State Significant Development Application (SSD 8784) 242-244 Beecroft Road, Epping

Council staff have reviewed the Response to Submission Report by Landcom (November 2019) and consider that the key concerns raised in Council's submission have not been adequately addressed and therefore Council strongly maintains its objection to the current proposal.

## SITE LINKS + ACTIVATION

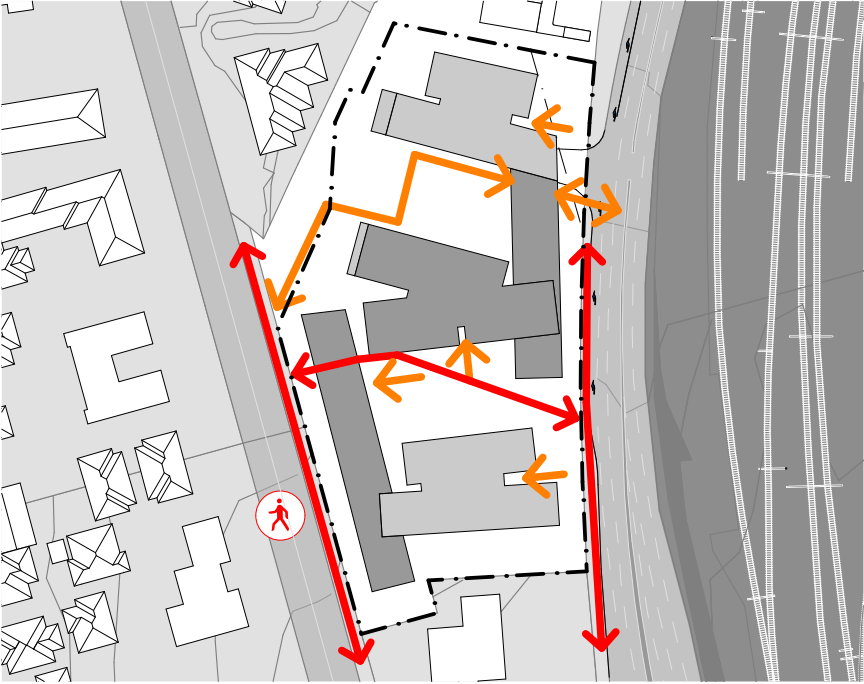
There is a Relative Level (RL) difference of approximately 5.5 metres from Beecroft Road to Ray Road, which presents access challenges along the proposed pedestrian link. Council staff have reviewed the Urban Design Drawings and raise the following concerns:

- the stairs and ramp design results in a fragmentation of landscaped areas;
- the ramp system is long and could be rationalised;
- the ramp system does not correlate closely with building foyers / entrances;
- stairs and ramp system conclude at Beecroft Road end together which is not compliant with Australian Standards; and
- It is unclear how ramp can be accessed from Ray Road footpath.

Council staff recommend the following design considerations:

- Potential separation of staircase and ramp will simplify the levels at landings (allowing for consistent ramp runs and flights), and could reduce the total length of ramps. It also may result in more consolidated landscaped area and consistency of grading for ramps;
- Further consideration of how the path of travel for the ramp will terminate in close proximity to entrances;
- Public stairs and ramps leading from footpaths to the ground floor level will require handrails to both sides of the stairs flights and ramp sides; and
- Provision of the RL plans to ensure compliant ramp design.
